From: Sarah Burrow <Sarah.Burrow@arun.gov.uk>
Sent: 07 May 2021 15:34
To: Planning.Responses <Planning.Responses@arun.gov.uk>
Cc: Simon Davis <Simon.Davis@arun.gov.uk>; Paul Cann <Paul.Cann@arun.gov.uk>
Subject: RE: Planning Consultation on: P/38/21/PL

Engineers Comments Regarding Surface Water Drainage

Application No: P/38/21/PL
Registered: 17th March 2021
Site Address: Little Sefter Farm Pagham Road Pagham
Grid Reference: 489511 100777
Description of Works: Extension to existing agricultural barn. This site may affect the setting of a listed building & is in CIL Zone 5 (Zero Rated) as other development.

PROJECT	BARN EXTENSION BARFOOTS - LITTLE SEFTER PAGHAM RD, BOGNOR REGIS WEST SUSSEX, PO20 1LN				
DRAWING	DRAFT PROPOSED EXTERNAL LEVELS & CONSTRUCTION FINISHES				
SCALE	PTN No	FC2846/03	REV	B	
Varies	DATE	JAN 20	INITIAL	MH	CHKD

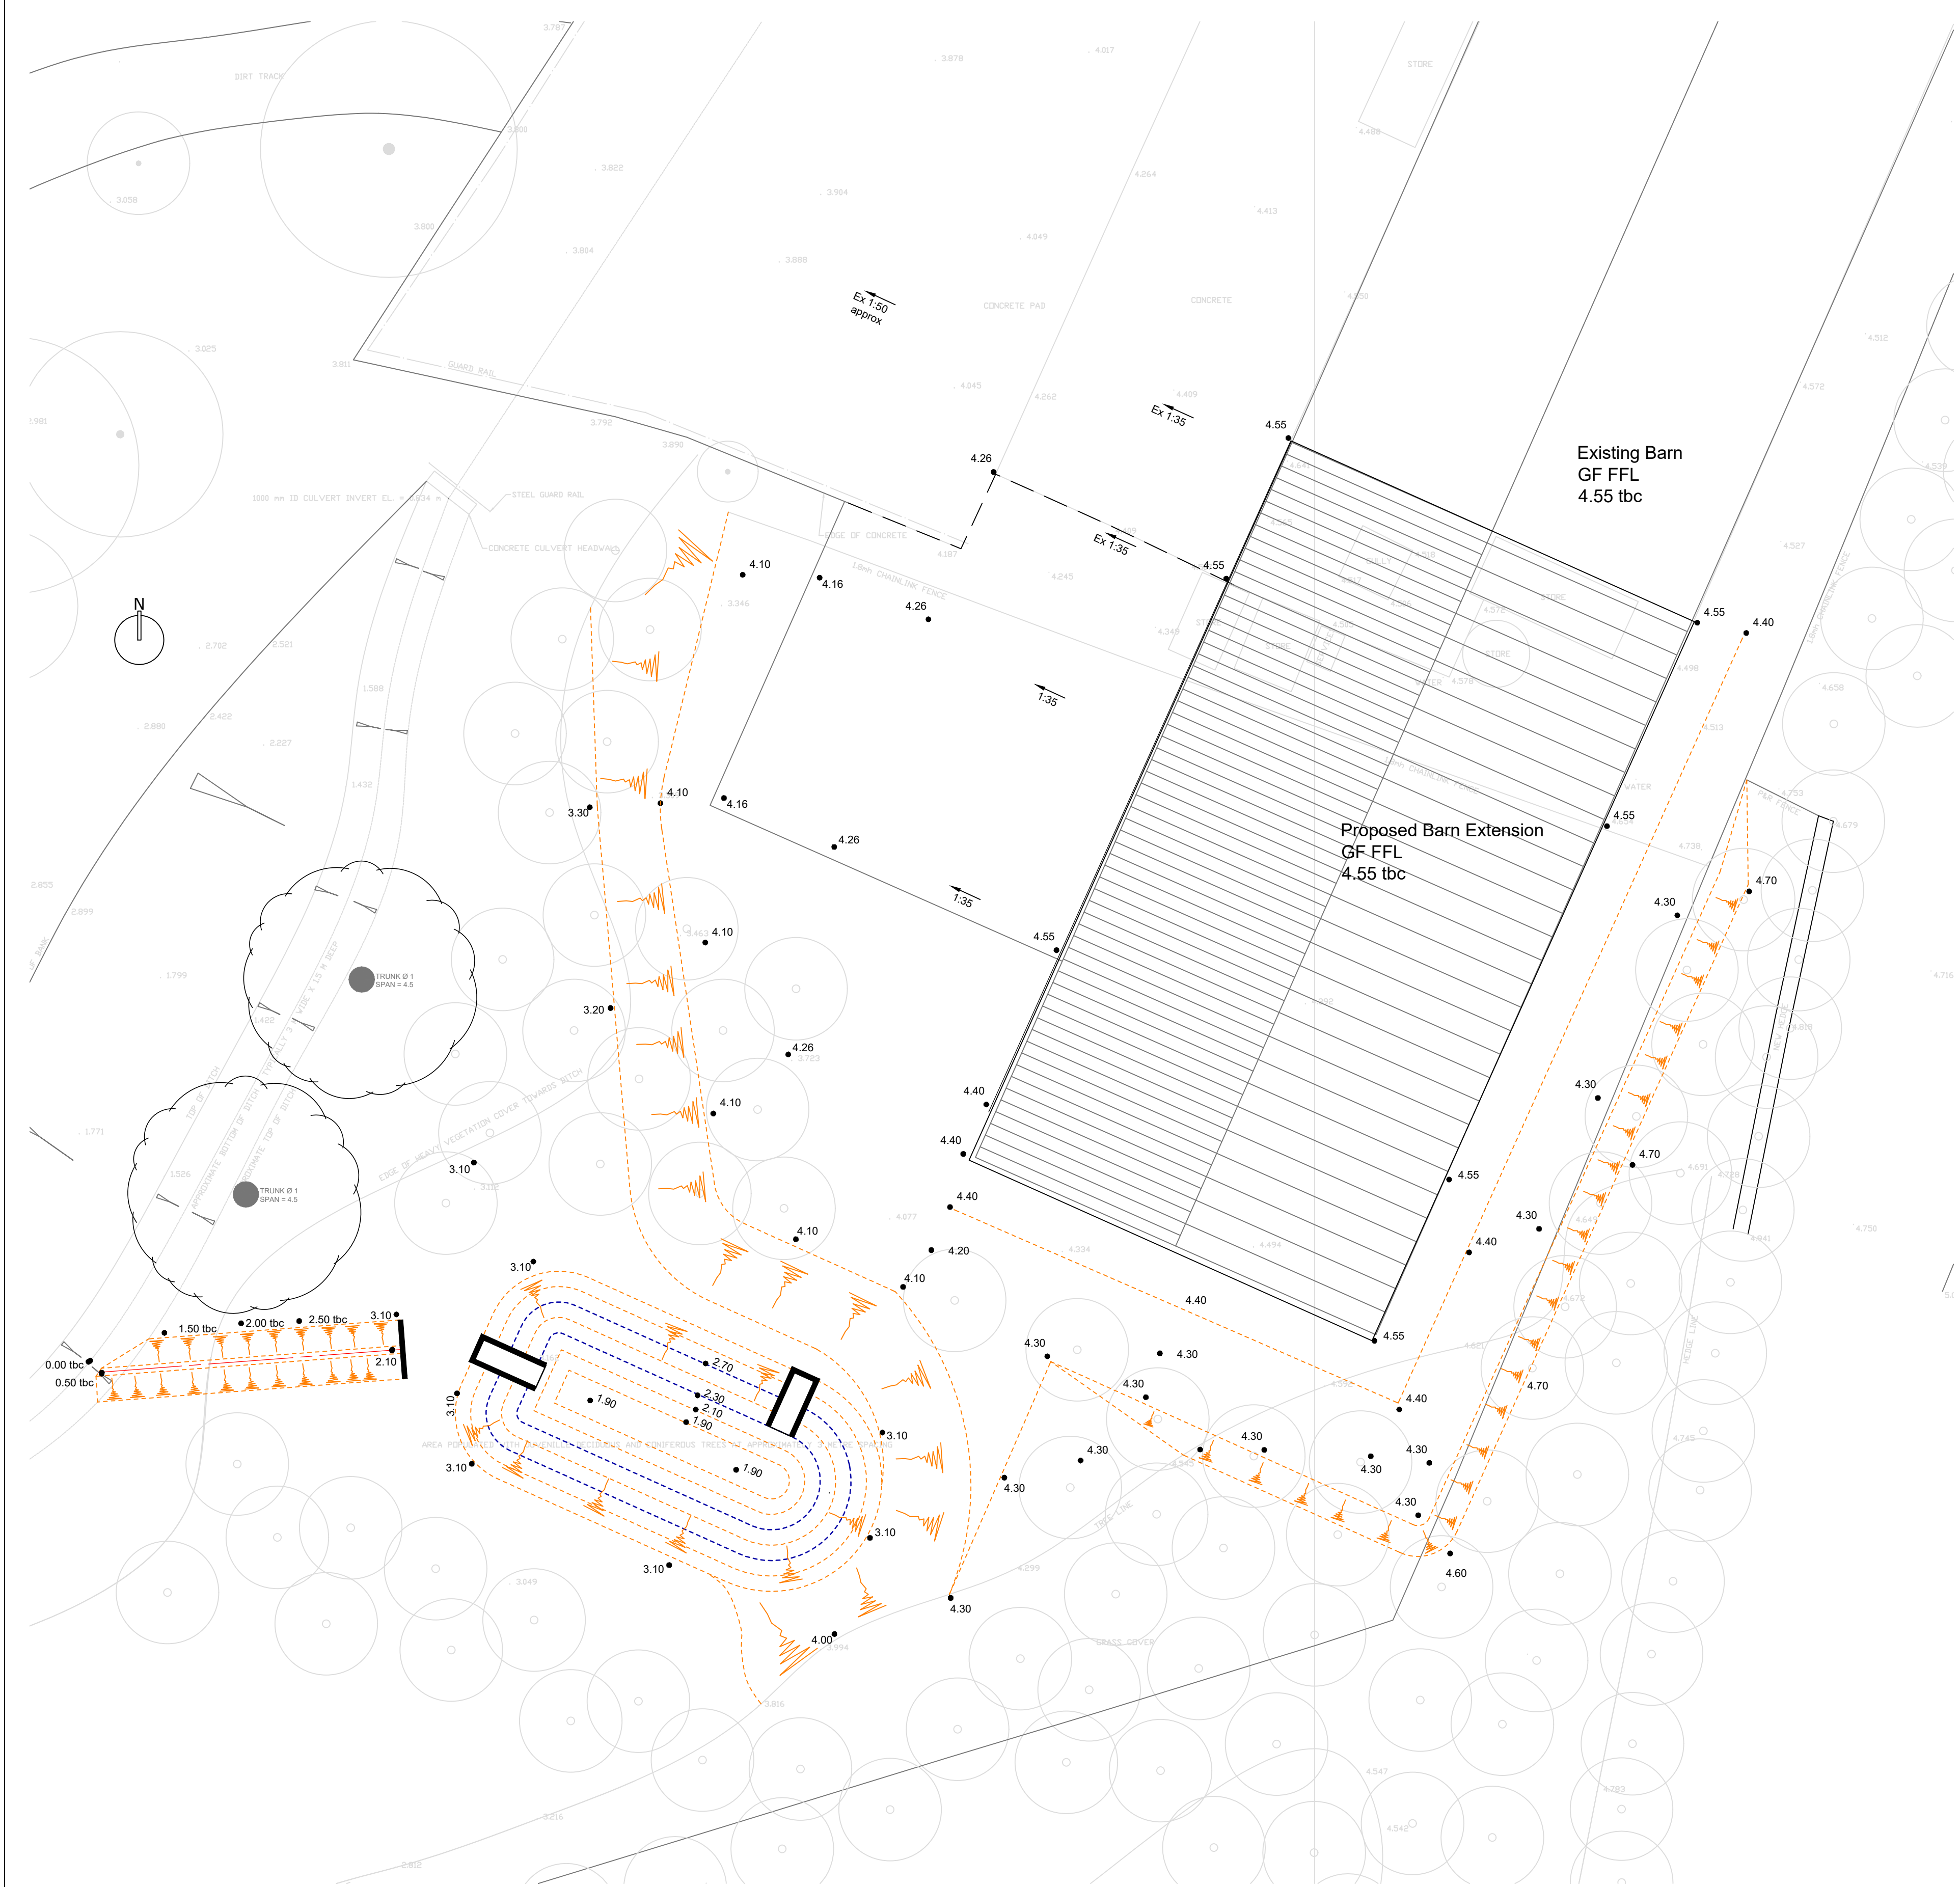
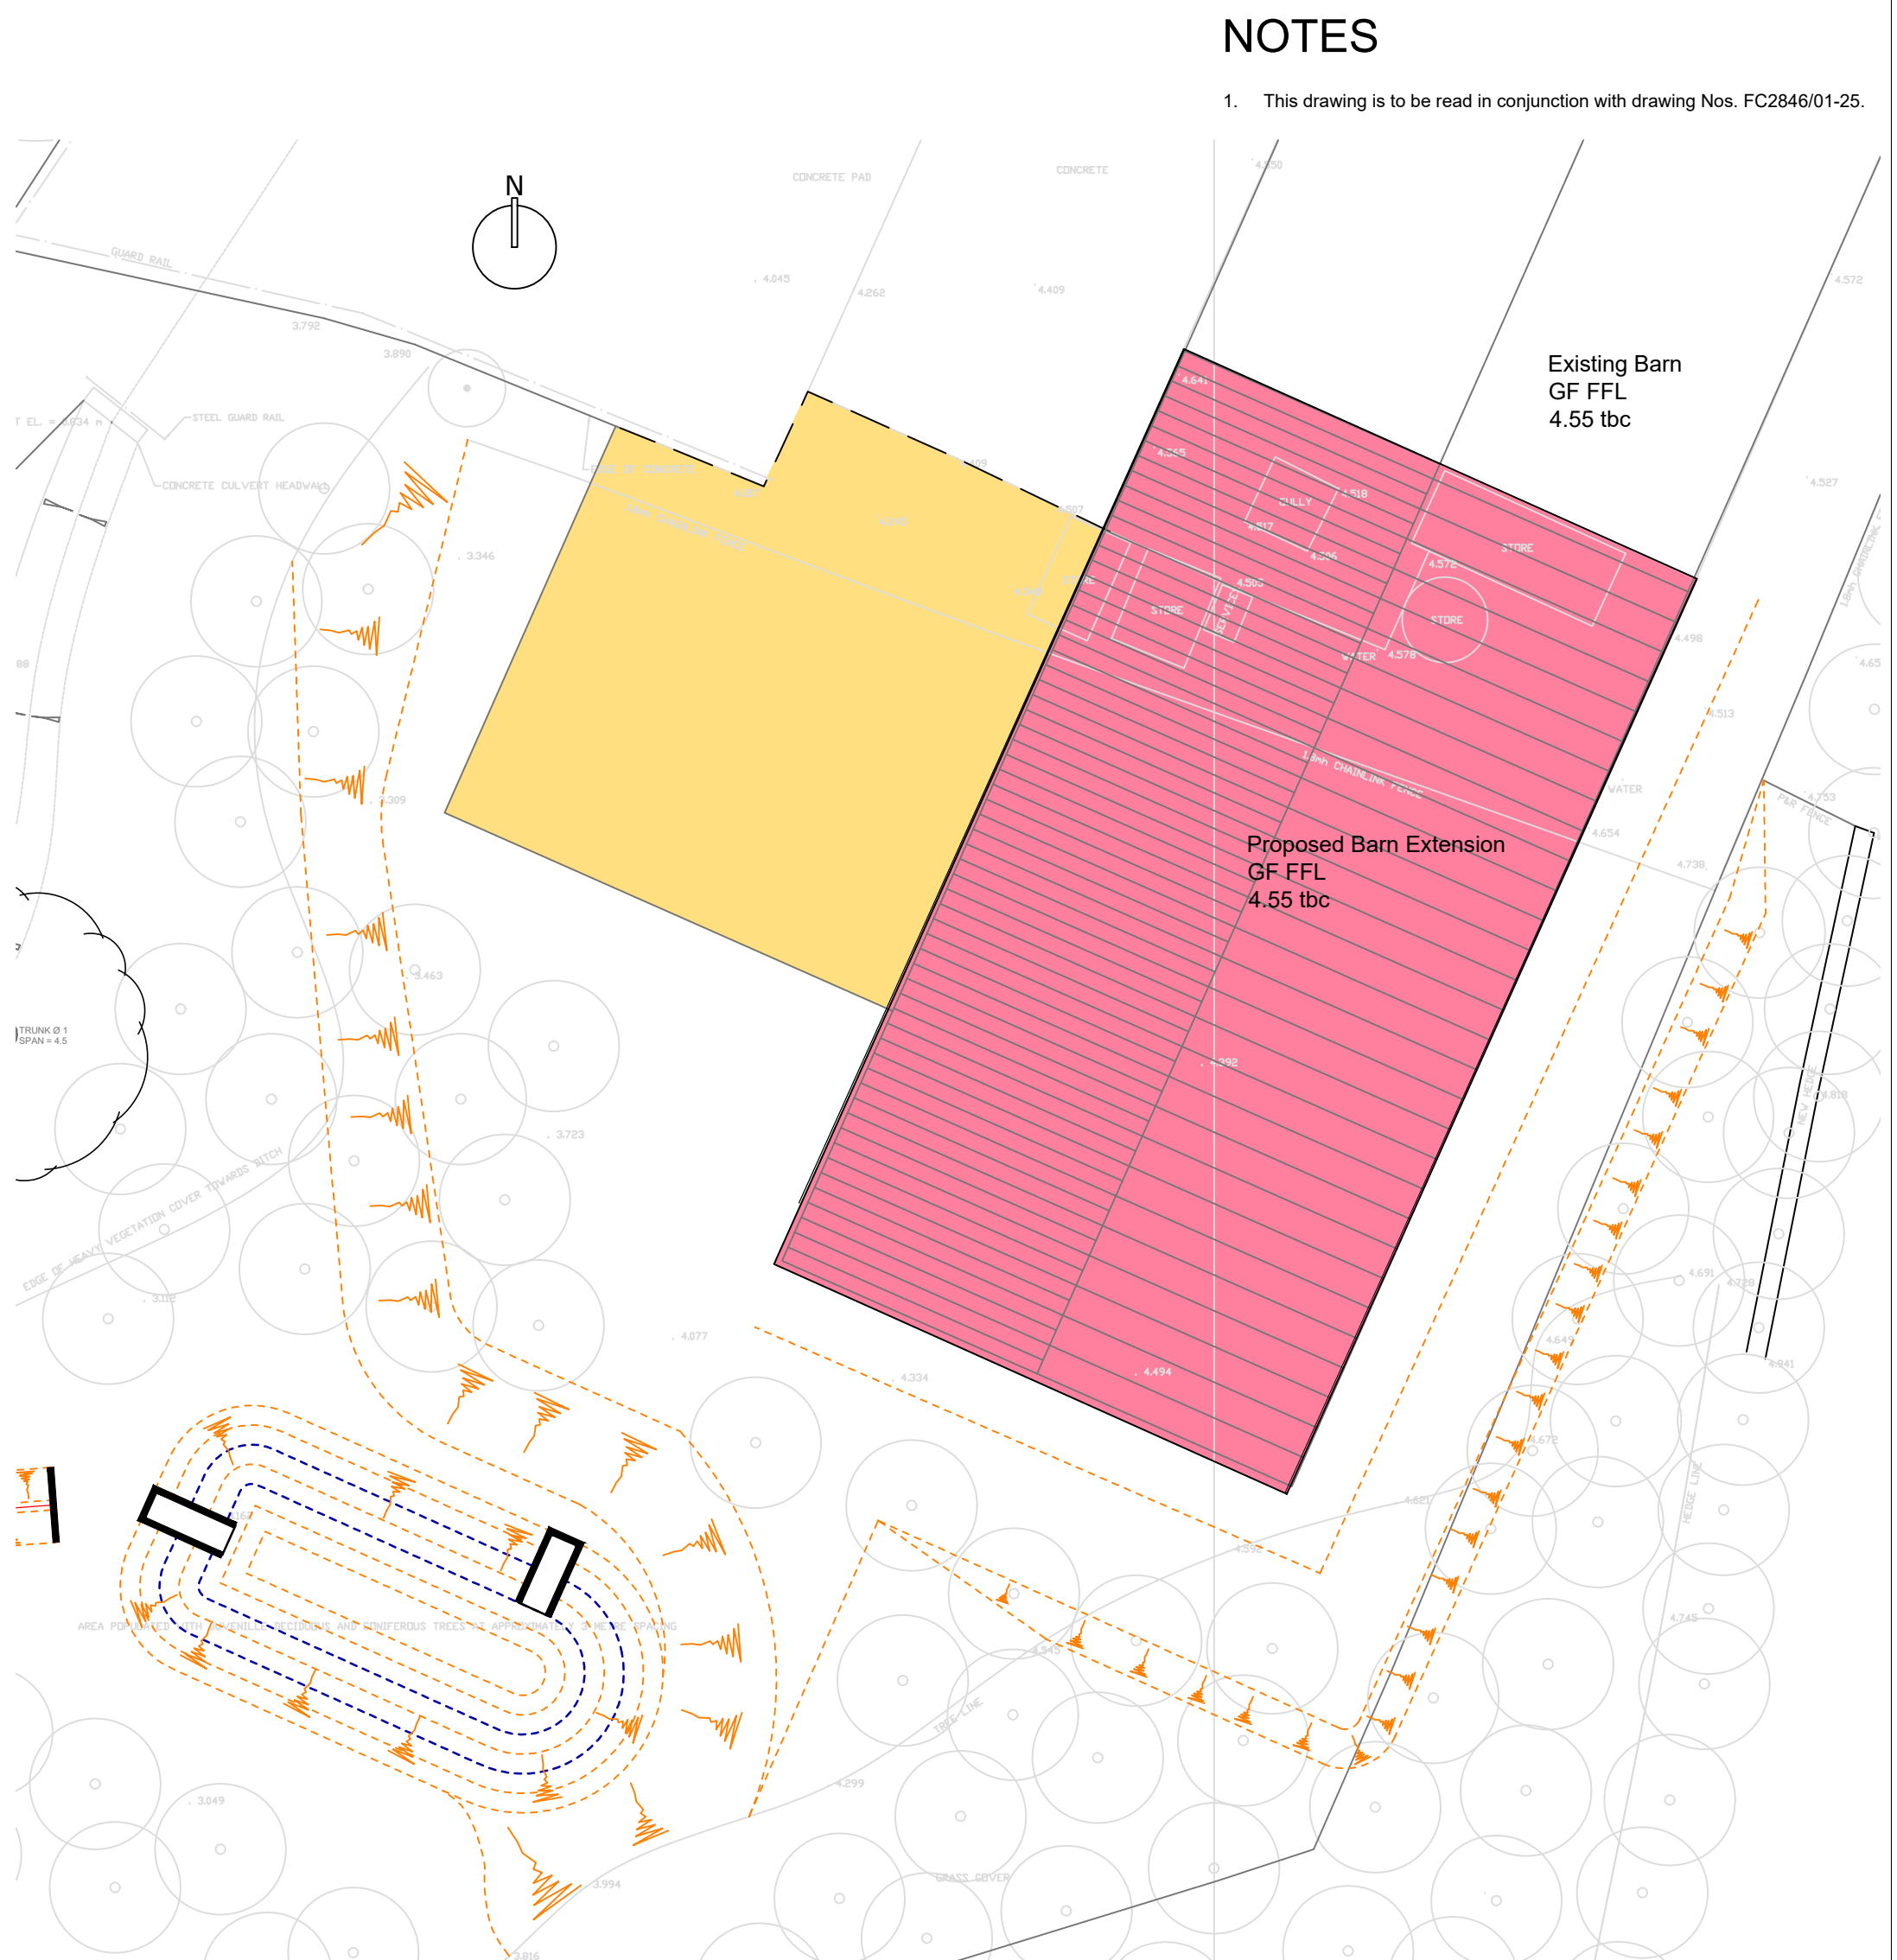
The applicant has considered and incorporated a surface water drainage strategy into the design and application. Infiltration testing has shown that infiltration is not a viable method for draining surface water on the site, therefore the applicant is proposing that surface water is drained to a balancing pond before discharging at a restricted rate to the watercourse on site. The proposed strategy is acceptable however there are details which require amendment, these will affect the calculations and the Drainage Layout, most importantly increasing the capacity of the pond and changing the hydrobrake.

The applicant has proposed a restricted run off rate post-development of 5l/s. This is significantly higher than the greenfield runoff rate and will not be acceptable for an approved design. It is expected that the runoff rate is reduced to 2l/s with features to reduce risk of blockage incorporated into the design.
